Our ref: SSD 8699

**Staged Redevelopment of Greenwich Hospital (Concept Proposal) (SSD 8699)  
97 - 115 River Road, Greenwich – Response to Submissions**

## ATTACHMENT 1

DRAWING TITLE:
SITE ELEVATIONS & SECTIONS
DATE:
AUGUST 2019
DRAWN:
JC
PROJ:
1213
PROJ ARCH:
BF
DRAWING:
IN.30
SCALE:
As indicated @ A1
REVISION:
P6

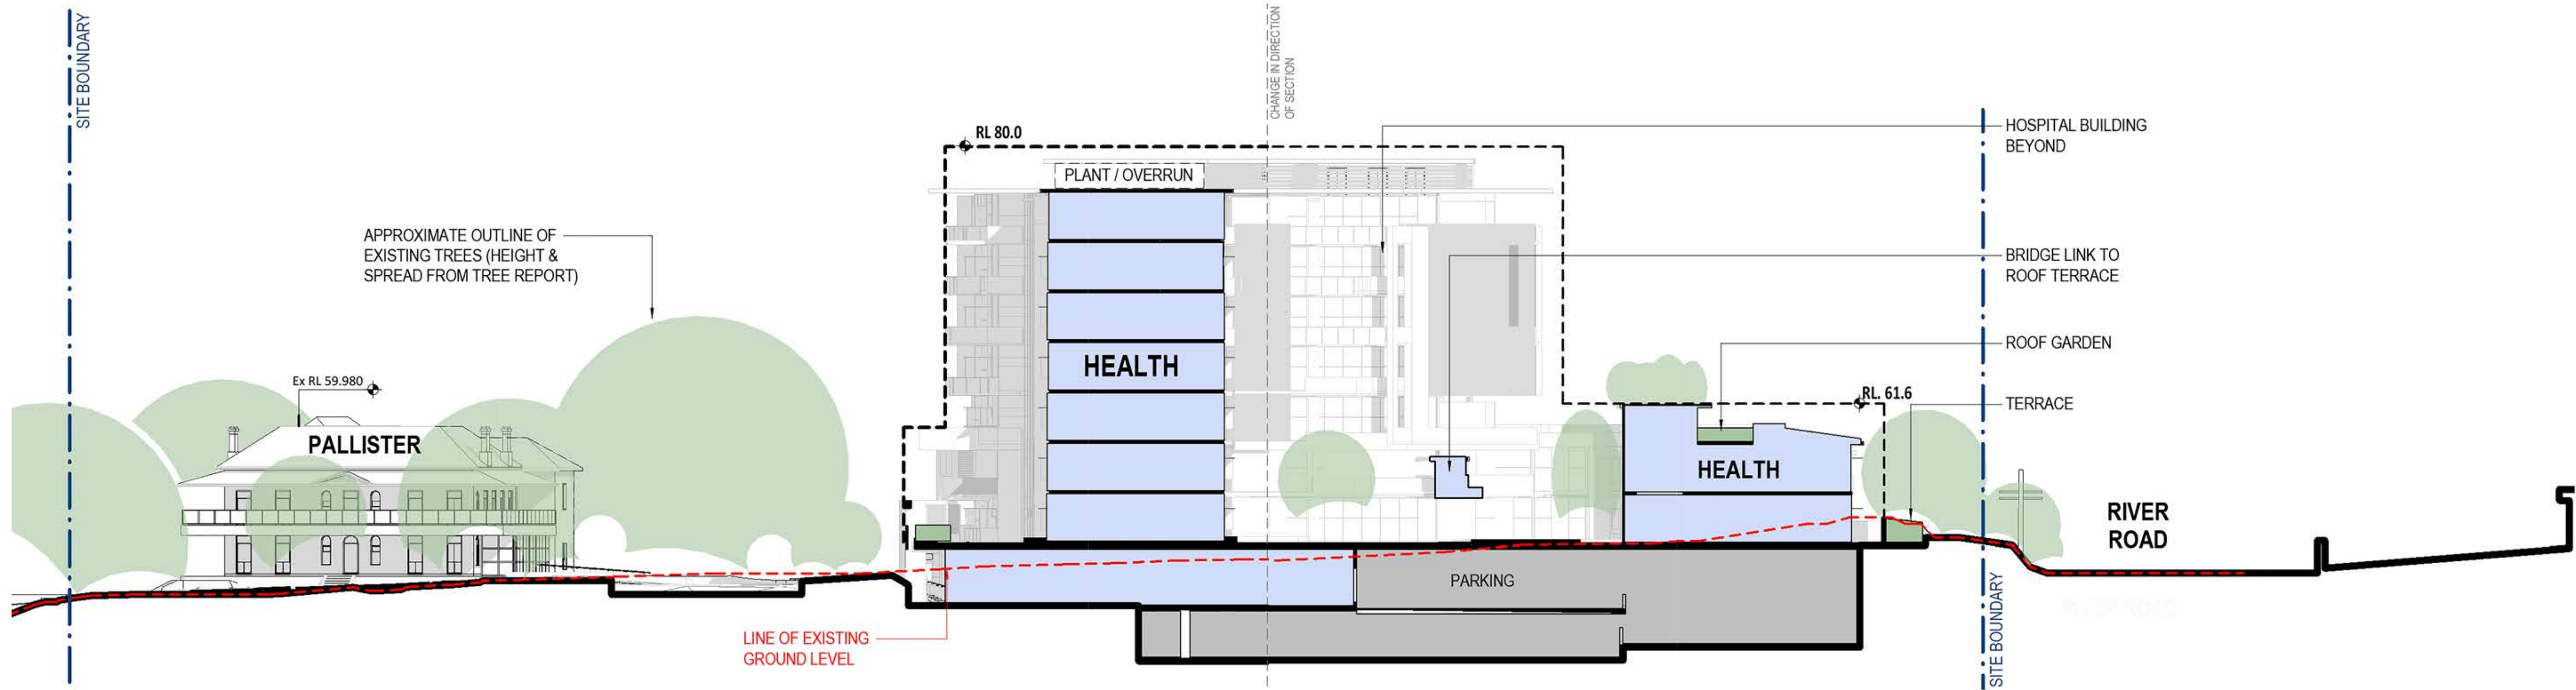
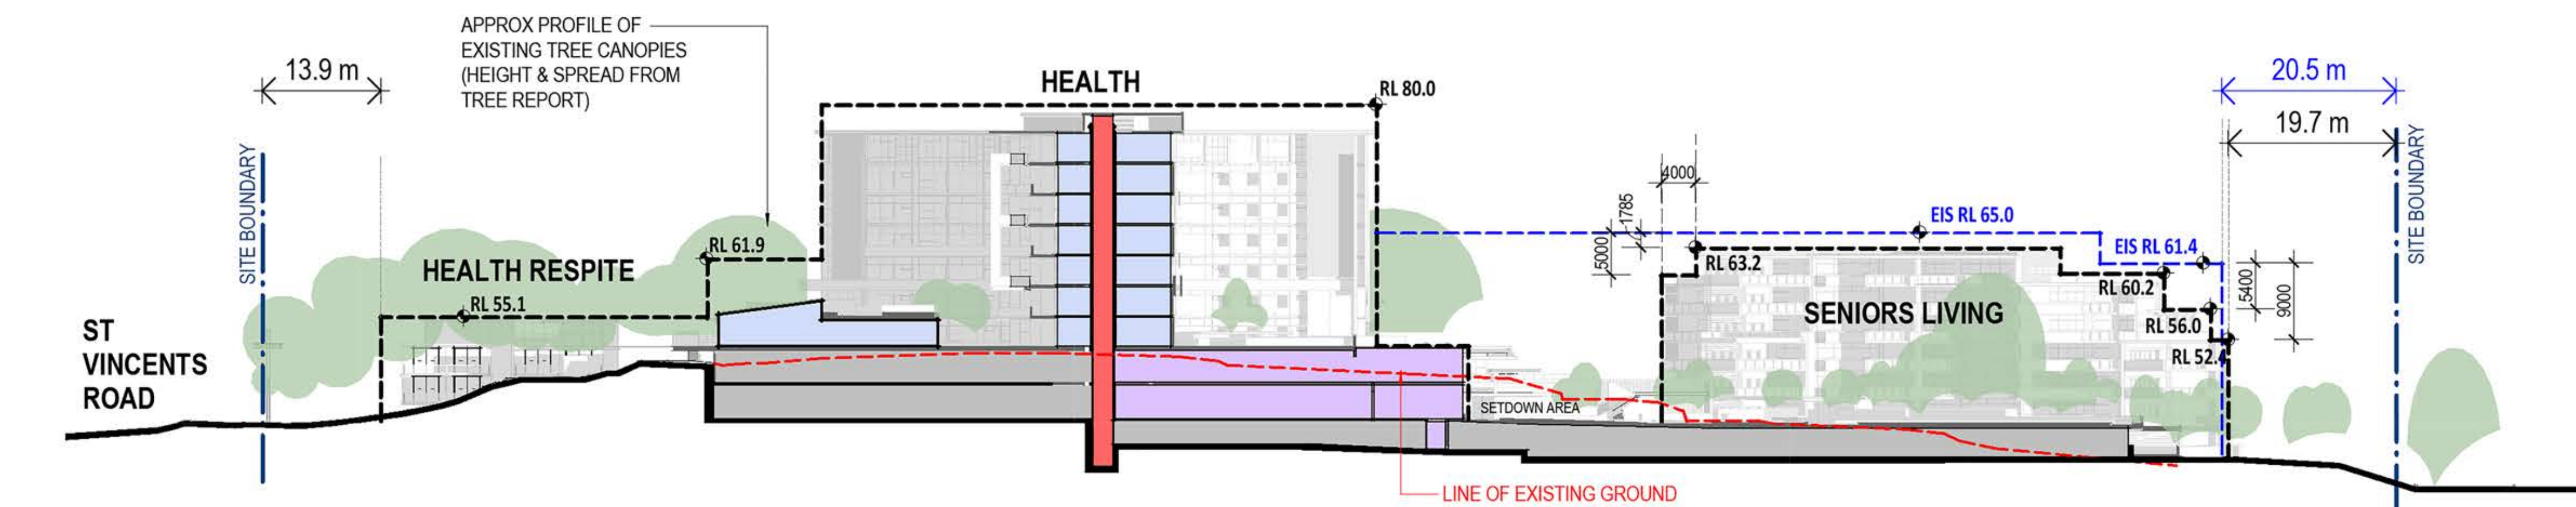
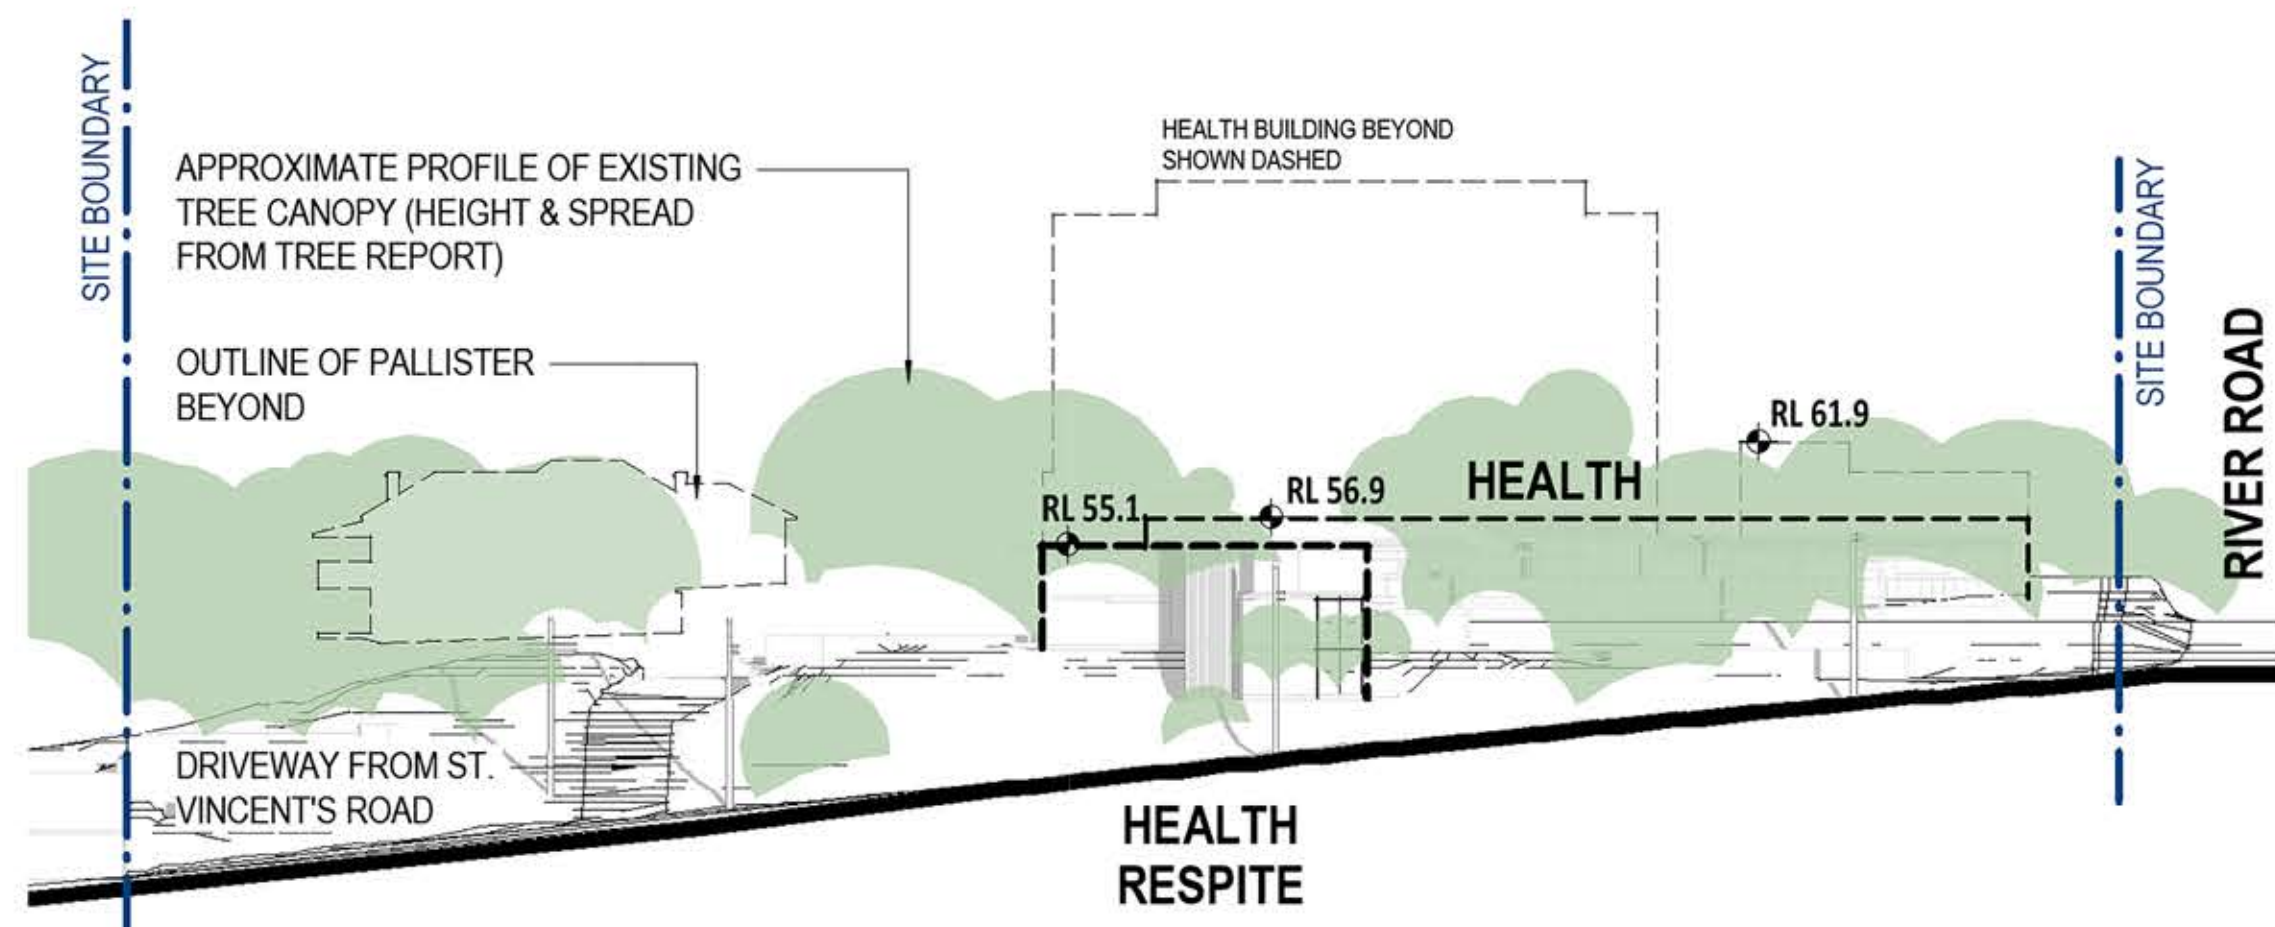
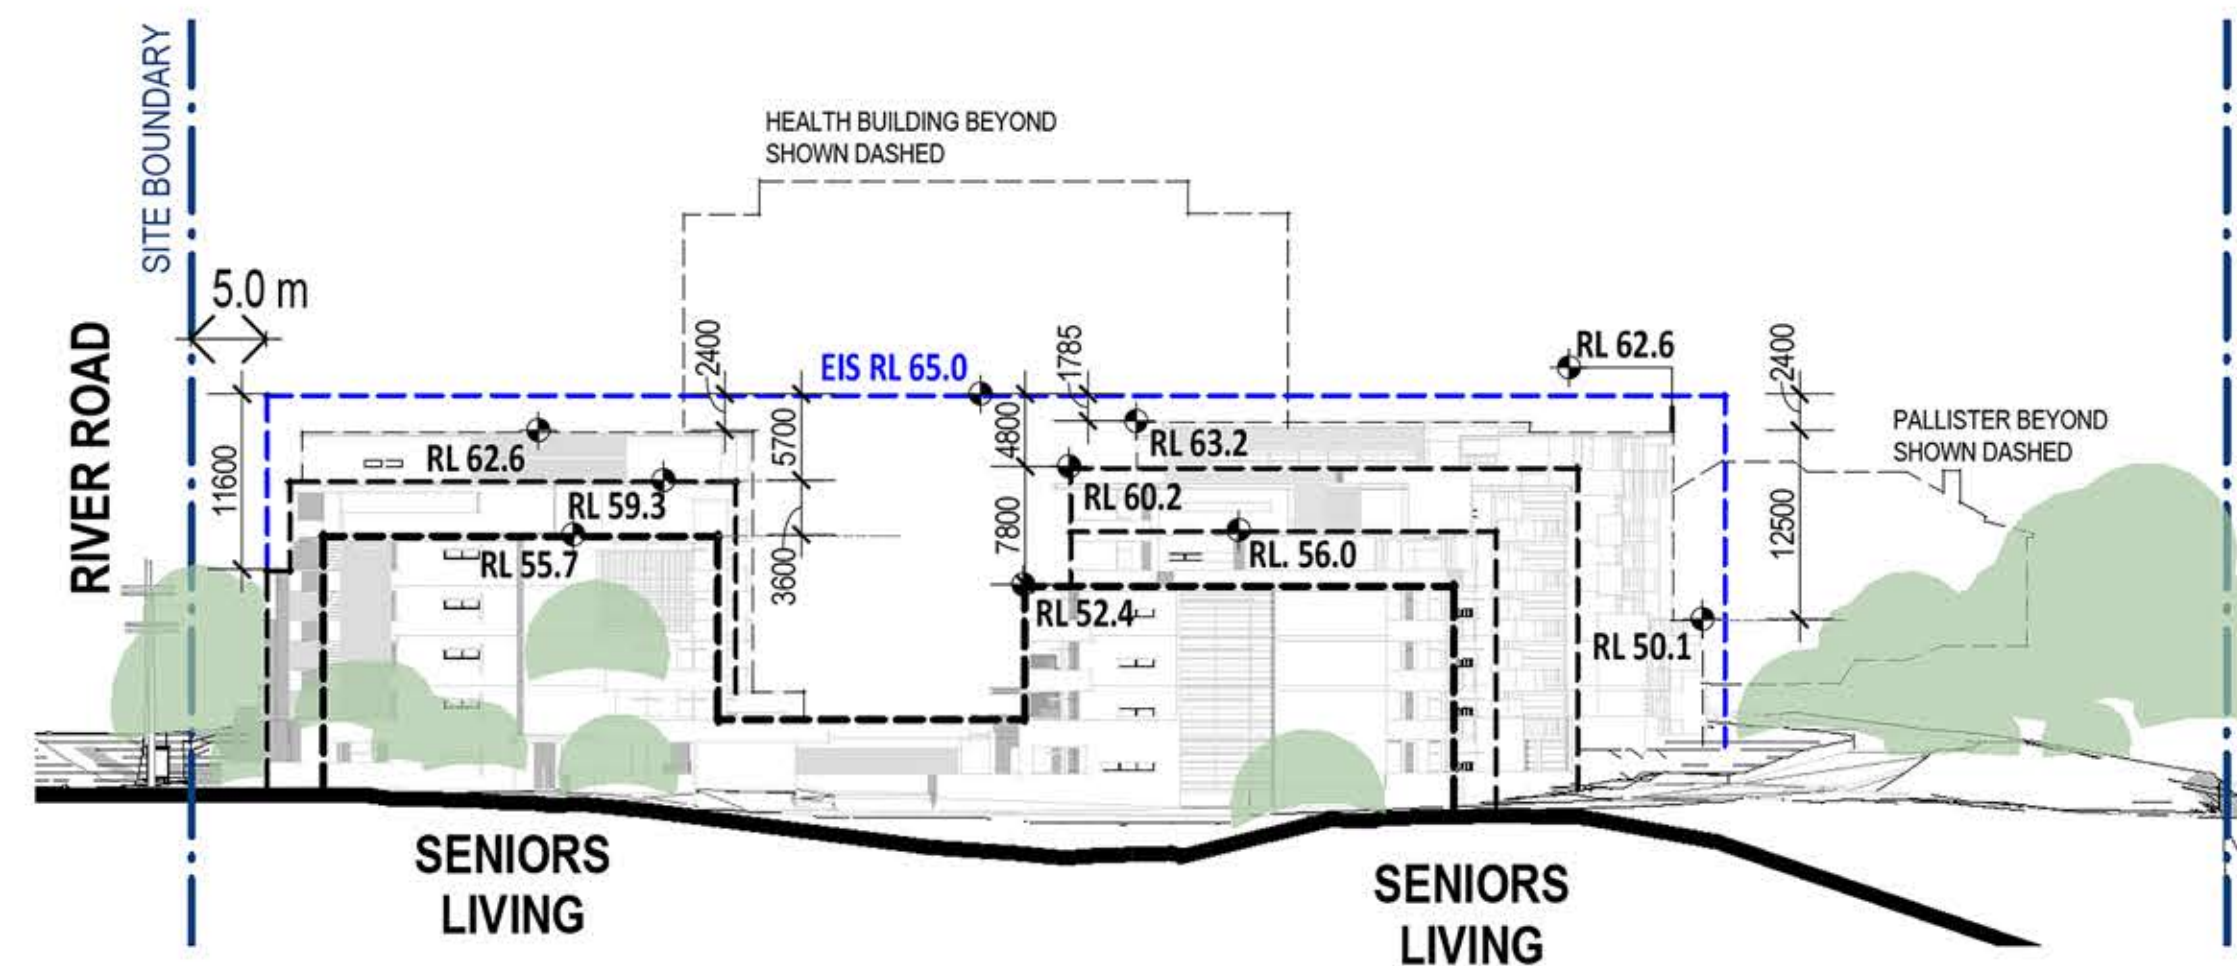
Further detail is required to undertake a comprehensive assessment of the concept proposal. In particular, the architectural plans must include the existing ground levels, the finished ground levels for the main elements of the development, additional sections throughout the site to demonstrate the relationship between the proposed buildings and Pallister House, and setbacks from the boundaries to establish the location of the envelopes.
